**Pitt Street South OSD Stage 2 (SSD 10376)  
Request for Additional Information**

I refer to your Response to Submissions for Pitt Street South OSD Stage 2 (SSD 10376). After careful consideration, the Department requests that you provide the following additional information:

LEVEL 2

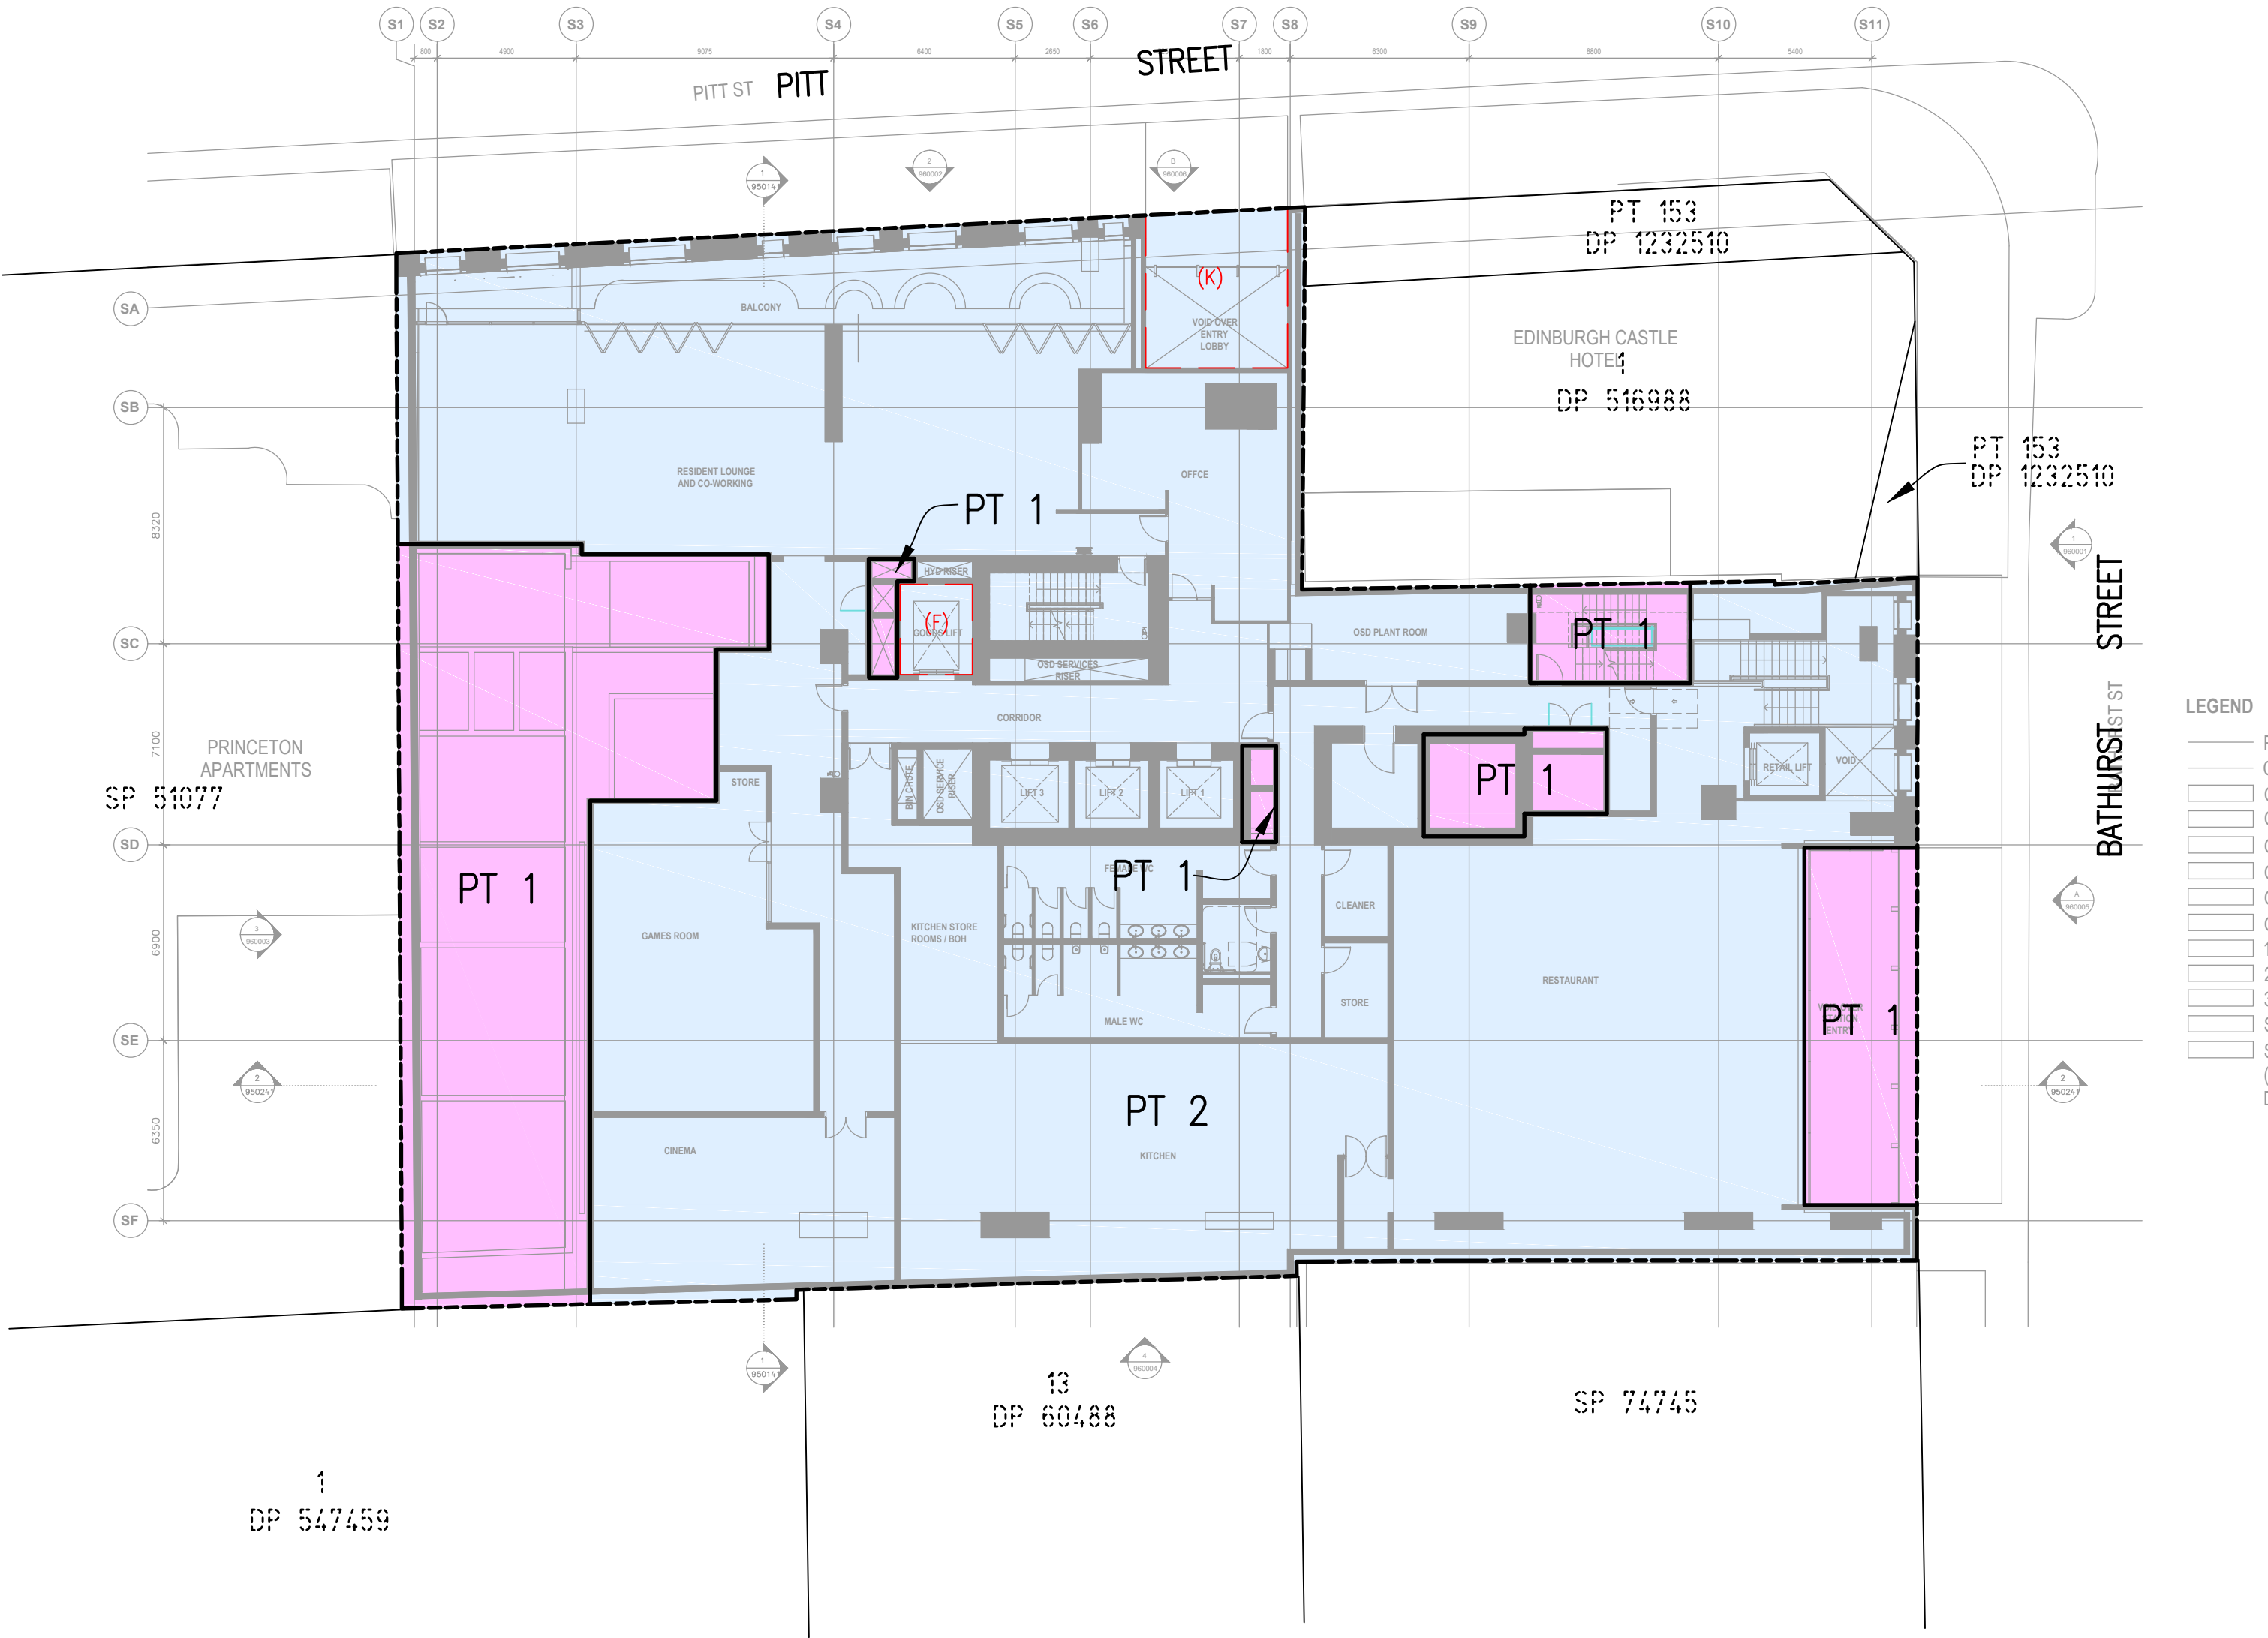
- Illustrate how the proposed 12 retail bicycle parking spaces and associated end of trip facilities would be accommodated on Level 2.
